November 29, 2023
Project No. T-8718

Subject: Response to City of Mercer Island Comments
3036 – 67th Avenue SE
Mercer Island, Washington

SHT **8** OF **9**

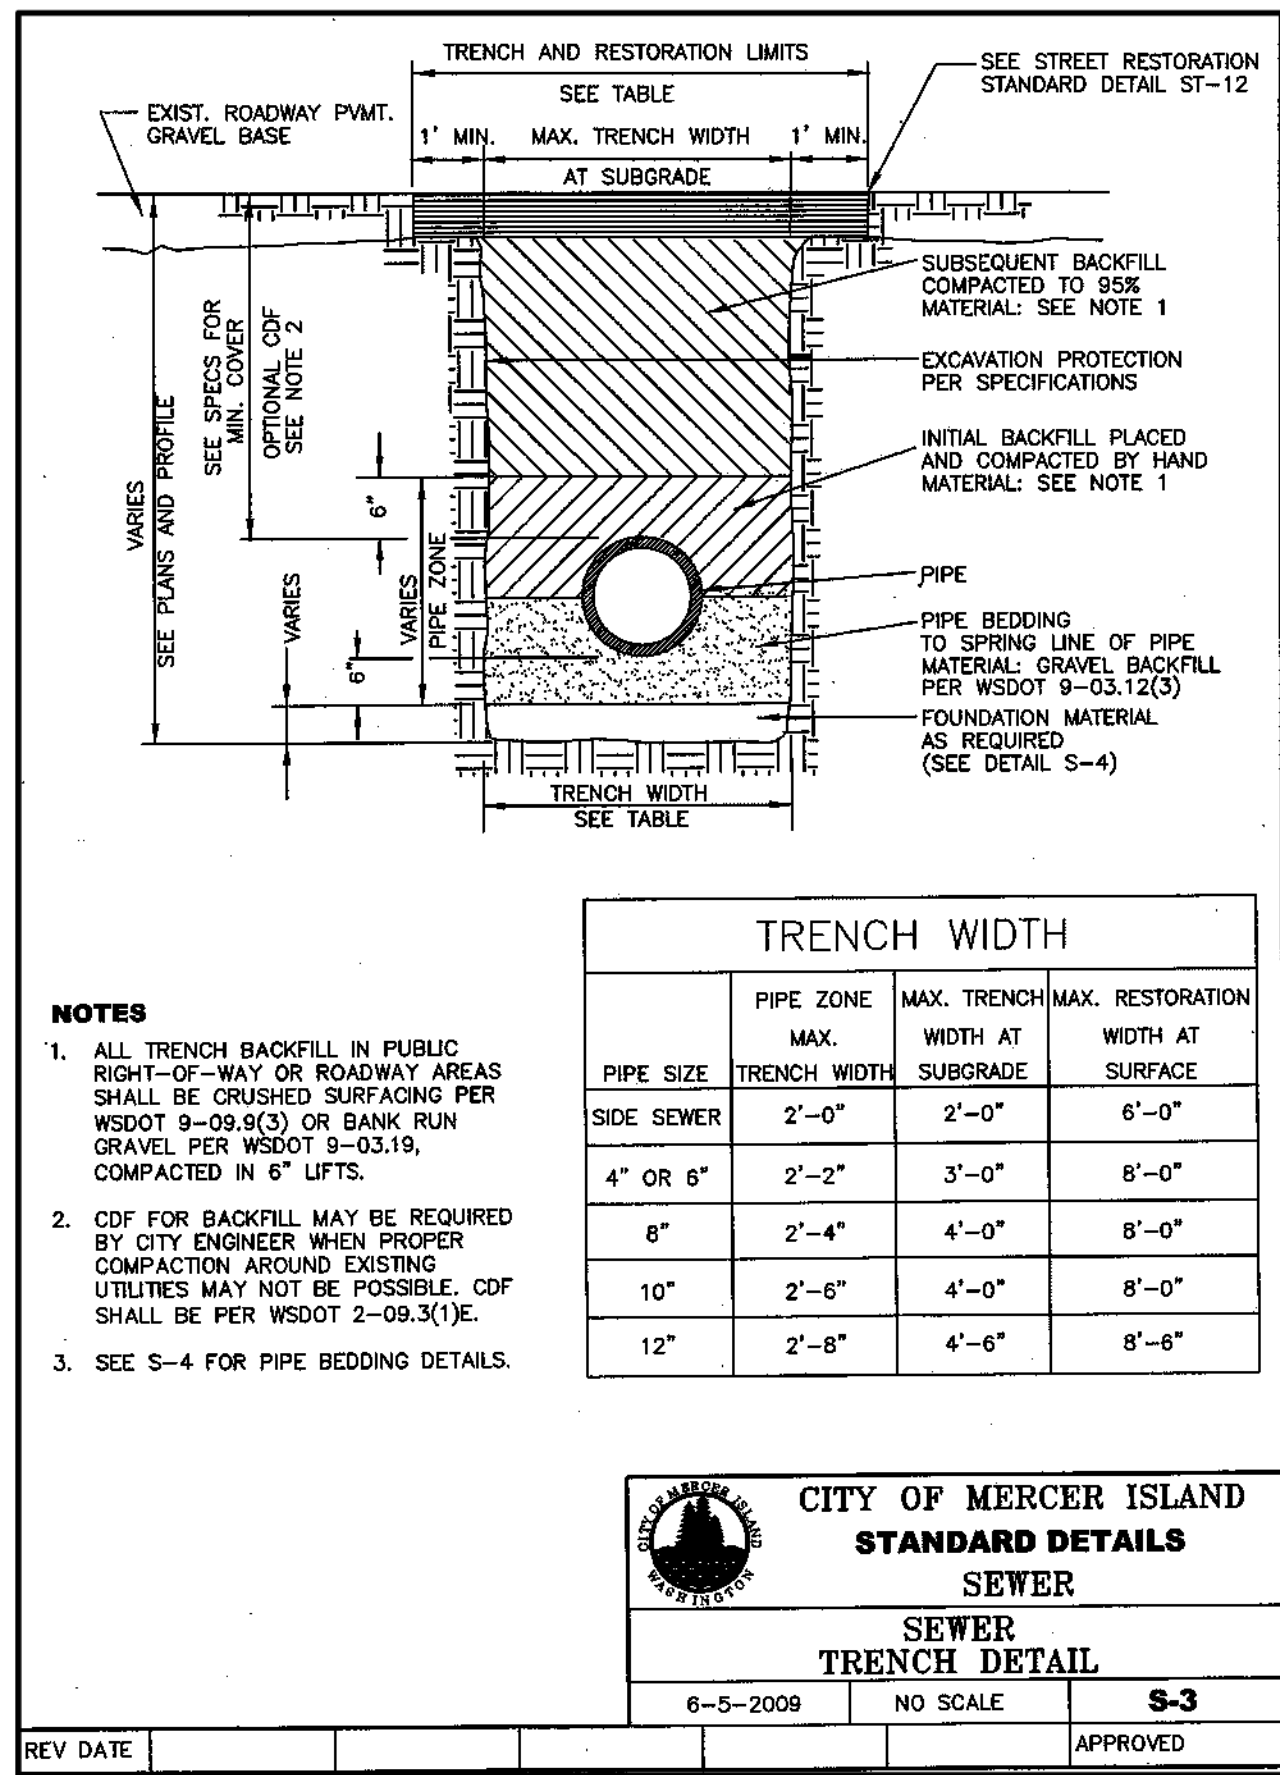
With the SUB5 plan set submission, please provide review letter from geotechnical engineer of record and updated statement of risk.

As requested, we have reviewed Sheets S-0.0 and S-0.1 prepared by Mulhern+Kulp dated November 27, 2023, Sheets A1.1, A2, A8, and D1 prepared by Architectural Innovations, P.S, dated November 27, 2023, and Sheets SP-01, TG-01, and DT-01 prepared by Atwell dated November 20, 2023. Based on our review, the project consists of developing the site with a new single-family residence, associated access, and utilities. The plans indicate the residence will be a three-story, wood-framed structure with an attached garage constructed at grade. An interceptor trench will be installed on the east side of the site with a bottom elevation of 95.70 feet.
